From: Andrew Wood
Sent: 15 March 2019 16:19
To: Lynnyrd Wolfe
Subject: FW: Planning Application FG/220/18/PL : Land adjacent to Elm Lodge, Tamarisk Way, Ferring, West Sussex BN12 5ER
Attachments: Revised Site Plan 22.2.19.pdf; Land Registry Scan 1983.pdf; Documents emailed to Laura on 19.2.19.pdf

RE: Planning Application FG/220/18/PL : Land adjacent to Elm Lodge, Tamarisk Way, Ferring, West Sussex BN12 5ER

Drawing Title
PROPOSED LOCAL AREA
PLAN

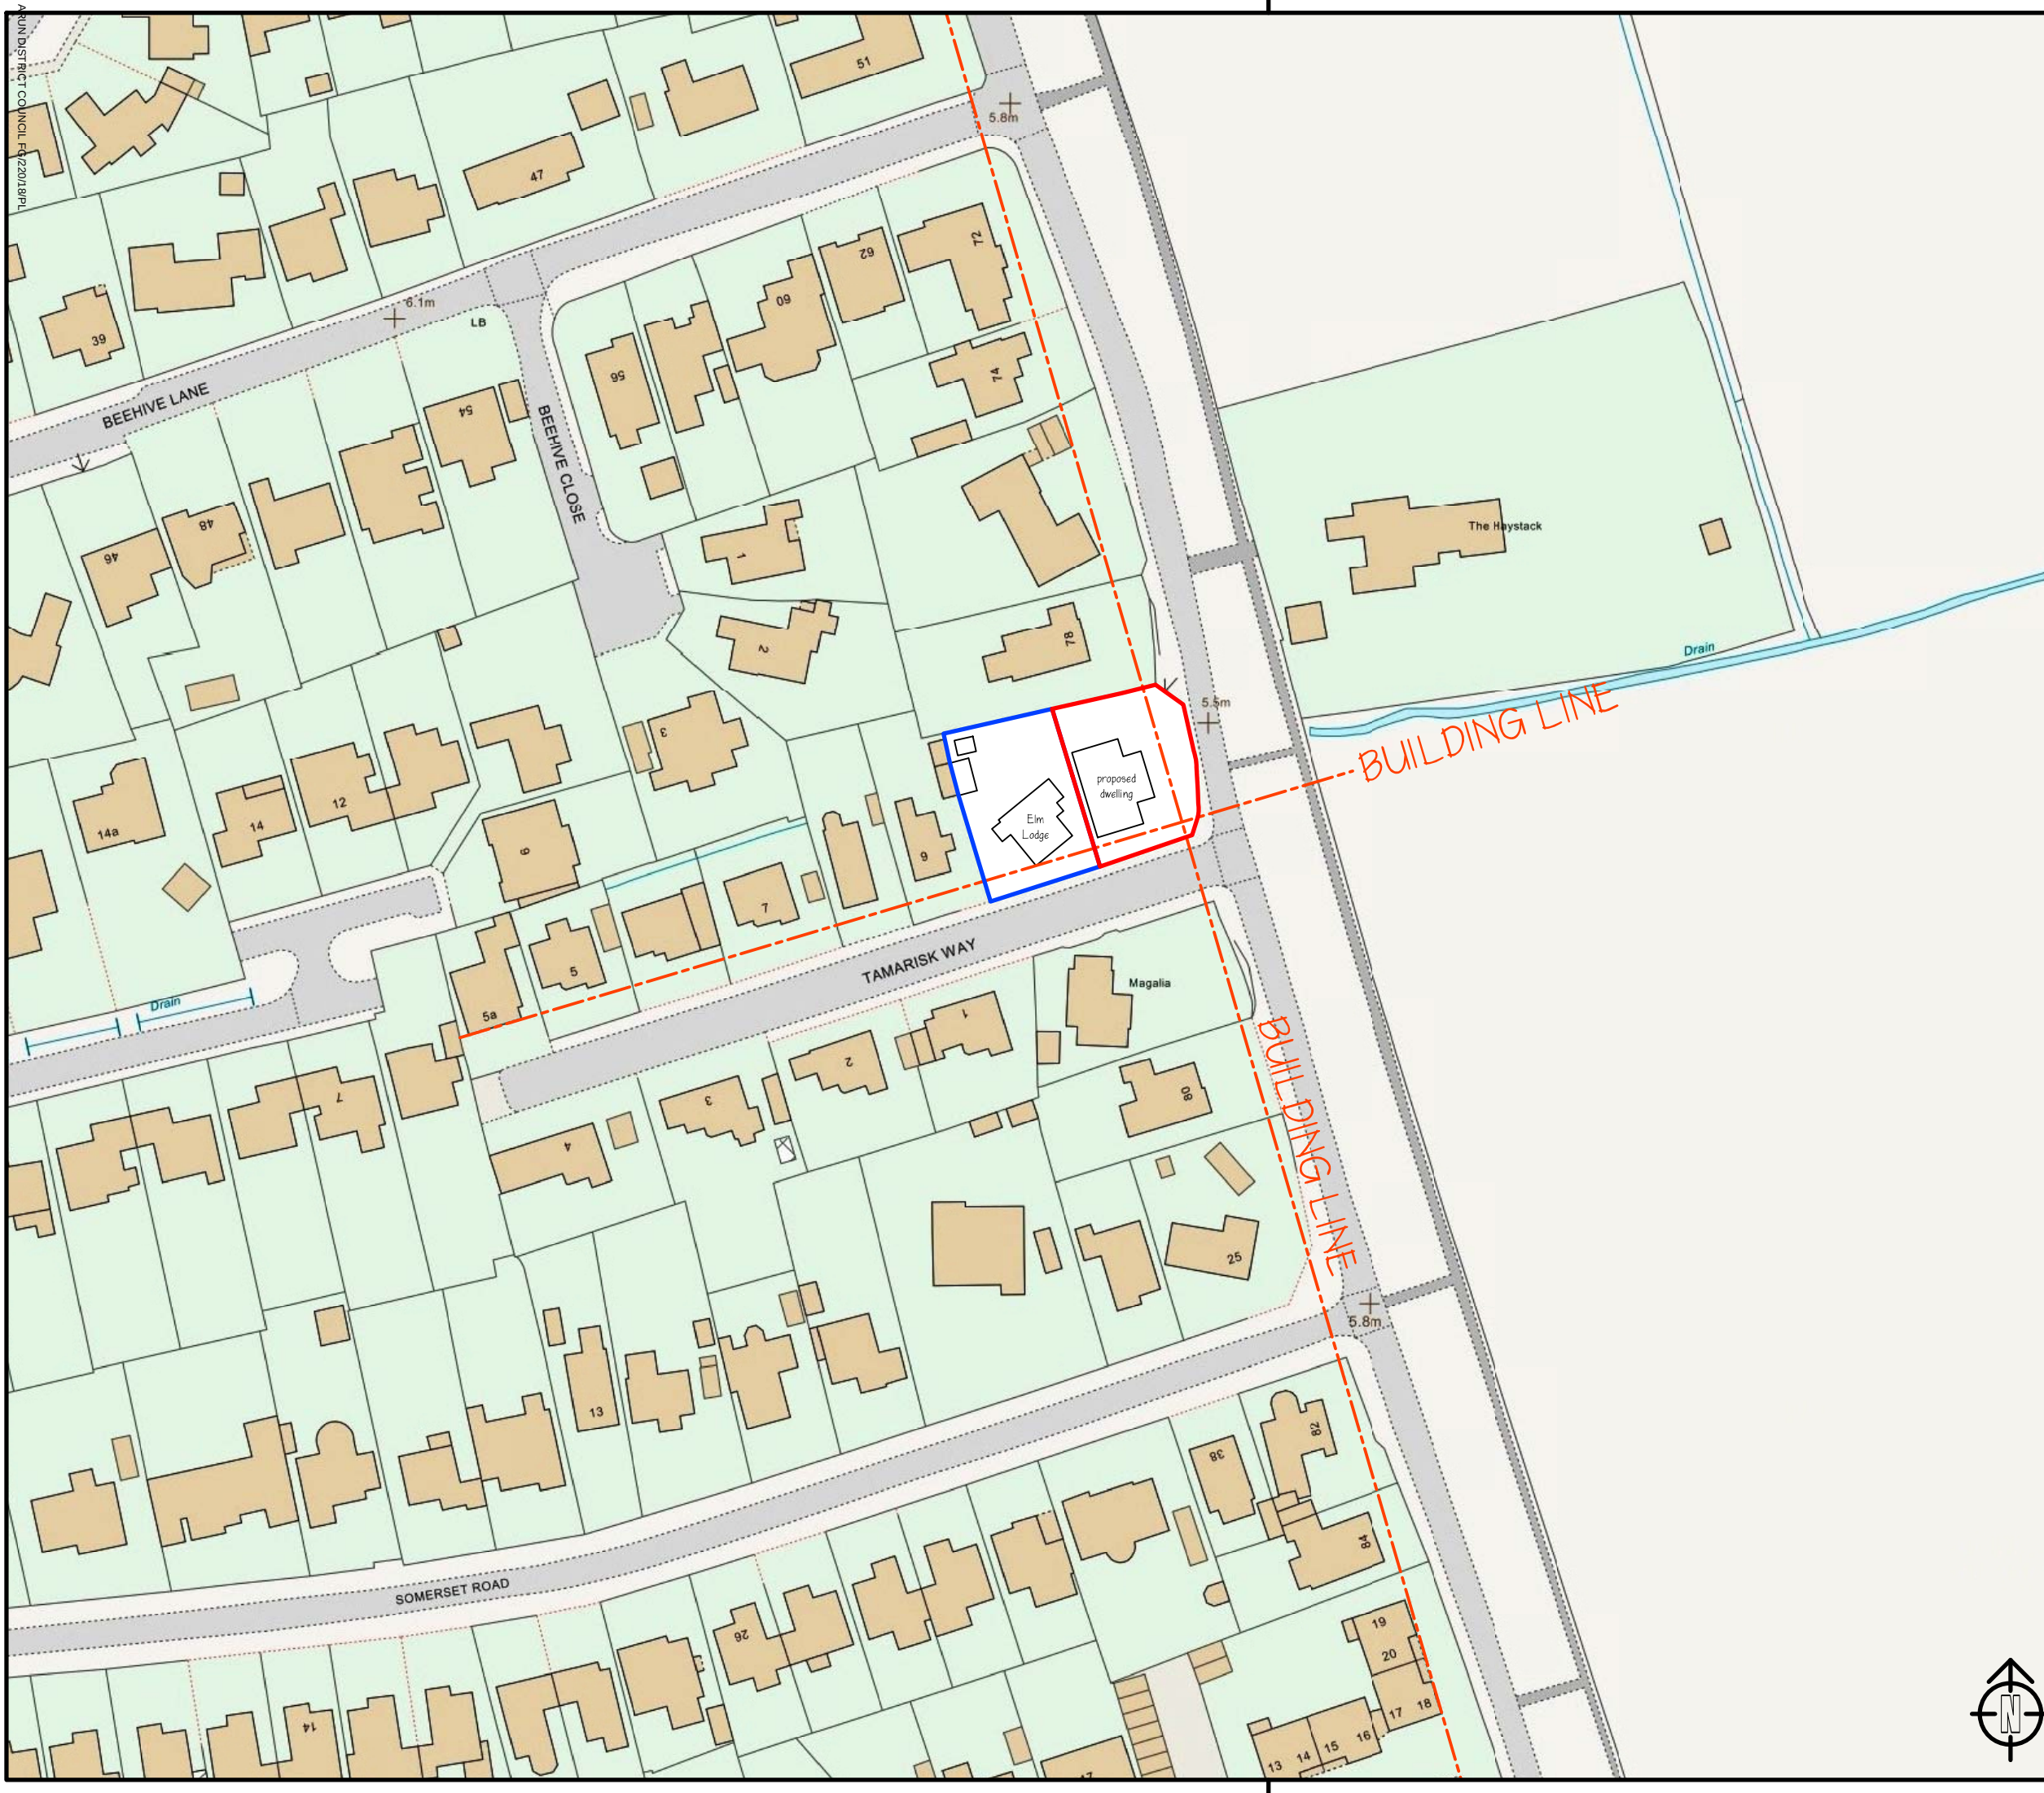
2. I am not keen to see the building go up to within 0.8m of the pond. Access and erosion are both a concern. I would therefore be keen to see the building layout revised to provide more easement. As shown on the proposed indicative part foundation section detail, short bore piles would be positioned a minimum of 3m from any edge of the pond, reducing the risk of erosion by eliminating trench foundations. Given a specialist would be designing the reinforcement/camp shedding for the existing edge of the pond (again, to be agreed with ADC by condition prior to commencement), this would ensure there will be no erosion. Given the building would only be cantilevered at one point within 0.8m of the pond, there is still a large area of access around the east and all other parts of the pond. We note that ADC has never had to access the pond to carry out any maintenance works to date, therefore query why there is such an onerous requirement for access now. We also note that ADC cannot currently access the pond with plant, since we have gates to the property and a further gate at the rear which would obstruct machinery from accessing our garden to carry out any maintenance works at all. ADC would have greater access to the pond as a result of the proposal, given there would be no obstruction when entering from the driveway. ADC Bylaws state that "Riparian Owners are responsible for maintaining the watercourse and any associated structures (i.e. headwalls, screen, weir etc.) and primarily to keep them free of any obstructions that may impede flow in the watercourse". There will be no obstructions which impede the flow in the watercourse, as demonstrated. We can easily complete any pond works to ensure it is upgraded from its current state (which has not been identified as obstructed or badly maintained by ADC to date) before commencement of any building works on site. The bylaws state that "Arun District Council may decide to exercise the permissive powers if it is approached by property owners affected by badly maintained or obstructed watercourses and they have been unable to get a 'riparian owner' to carry out necessary works. In the first instance, Arun District Council will try to resolve the problem informally by explaining 'riparian ownership' responsibilities and agreeing the work that is required to the watercourse to rectify the problem. If this approach is unsuccessful, Arun District Council may require and enforce 'riparian owners' to carry out works using powers under S25 of the Land Drainage Act 1991 where the flow of water is impeded and the condition needs to be remedied." Given we as riparian owners will be able to access the pond from all sides to carry out any works in accordance with the bylaws, we do not understand why ADC would need access to our land, particularly from multiple different points given they cannot access it at all at present. It is the landowners (Riparian) responsibility to complete maintenance works, if we are informed of an impediment to flow we request landowners complete this maintenance. If they refuse to complete the work, we use our powers under S25, and this can be accompanied by forced entry through gates. The proposed layout will make it exceptionally difficult to complete maintenance. Irrespective of planning it is fairly evident that an impediment to flow is present, so we will be requiring you as landowners to complete maintenance to the pond to ensure silt levels are reduced and culverts are in an appropriate condition. Ongoing maintenance (including to any retaining walls) will be required after construction is complete, this is when the proposed site layout in my opinion would prevent this work.

To summarise, on Friday 22nd February I emailed a Revised Proposed Site Plan (attached) to Laura which showed the proposed dwelling repositioned on site to provide greater access around the pond for future maintenance and minimise the risk of erosion resulting from the works. Since Laura is away until 4th March and the application is due to be determined on 8th March, I would greatly appreciate your comments so that we can revise the planning application drawings and submit these to Andrew Wood in advance of the 8th March, should Arun District Council Engineering Services deem the revised proposal acceptable.

In order to hopefully alleviate your concerns, I attach an alternative proposal to reposition the proposed dwelling to provide greater access around the pond for future maintenance and minimise the risk of erosion resulting from the works. Please could you let me know your thoughts on the attached proposal, and whether this solution would be acceptable? If so, we can then amend the planning application drawings for Andrew accordingly.
